**Application no: 18/00904/F-2**

**Location:** Glebe Farm, Boddington Road, Claydon, Banbury, OX17 1TD.

## **Transport Schedule**

**Date: 03 April 2019**

**Refer to: AdamCM-Appendix K (PropSitePlan)/  
Drawing ref: A05/010G**

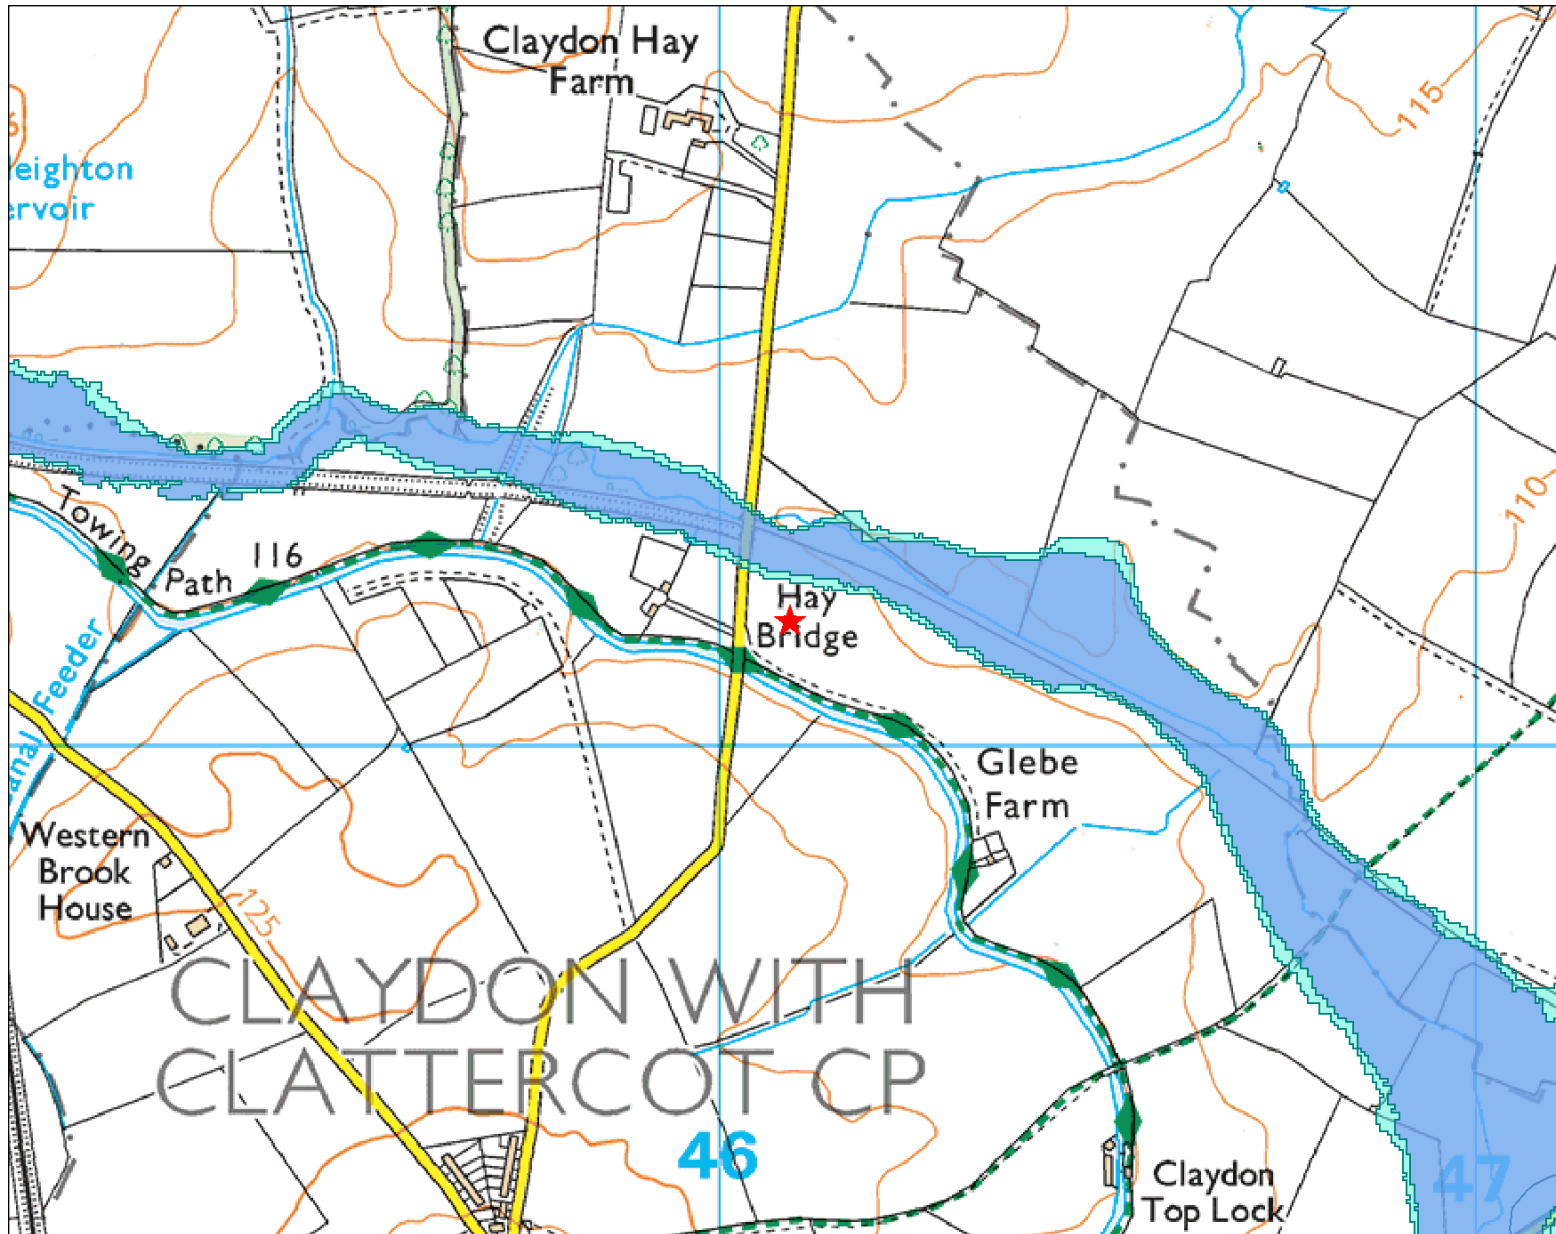
Infiltration is being proposed for the access and parking areas, but it is unlikely that infiltration will be feasible either due to low permeability or high groundwater as the areas will be located within or adjacent to flood zones 2 and 3. If infiltration is to be proposed then infiltration testing and groundwater monitoring will be required to demonstrate it will be feasible.

A gravel surface as proposed for the access and parking areas is inappropriate as it looks like it will be in constant use. The proposals will need to ensure that all water within areas that are being used will be collected and treated appropriately as well as being appropriately managed to not increase flood risk elsewhere.

Although permeable surfaces are being proposed, they will need to provide storage as well either within the permeable system or a separate attenuation system. This does need to be quantified for the whole site and will require a controlled outfall to an existing watercourse or surface water drainage system if infiltration is not feasible.

There will be a requirement for some areas of the sites to be accessed by HGV's. These areas will need to be a heavy-duty permeable system or hardstanding draining to a separate SuDS system. It will need to be demonstrated that the drainage system will be appropriate for the lifetime of the development.

At the moment, the calculations provided in the flood risk assessment have only included the access road served by the swale. The proposed buildings as well as all the access roads parking areas and other hardstanding areas need to be included and it needs to be demonstrated that all surface water on the site will be managed appropriately not to increase flood risk elsewhere. The proposed drainage scheme

- Evidence that the proposed flows from the site will be restricted to greenfield run-off rates for all events up to and including events up to and including the 1 in 100-year event + allowance for climate change (Currently 40%);

- Evidence that the proposed runoff volume will not increase the existing greenfield volume for the corresponding event;
- If infiltration is proposed, detailed infiltration testing to DG365 and extensive groundwater monitoring has been provided to demonstrate infiltration is feasible;

- Details of how the drainage scheme has been designed to incorporate SuDS techniques to manage water quantity and maintain water quality in accordance with best practice guidance including the latest SuDS Manual C753;

- Drainage plan showing the location of the proposed SuDS and drainage network with exceedance flow routes clearly identified;
- Drainage calculations for all rainfall events up to and including the 1 in 100 year plus climate change event to demonstrate that all SuDS features, and the drainage network can cater for the critical storm event for its lifetime;

- Details of how the scheme shall be maintained and managed after completion;
- Construction phase surface water management plan including details of how water quality and water quantity shall be maintained and managed during and after construction; and

- The submission of evidence relating to accepted outfalls from the site, particularly from any third-party network owners.
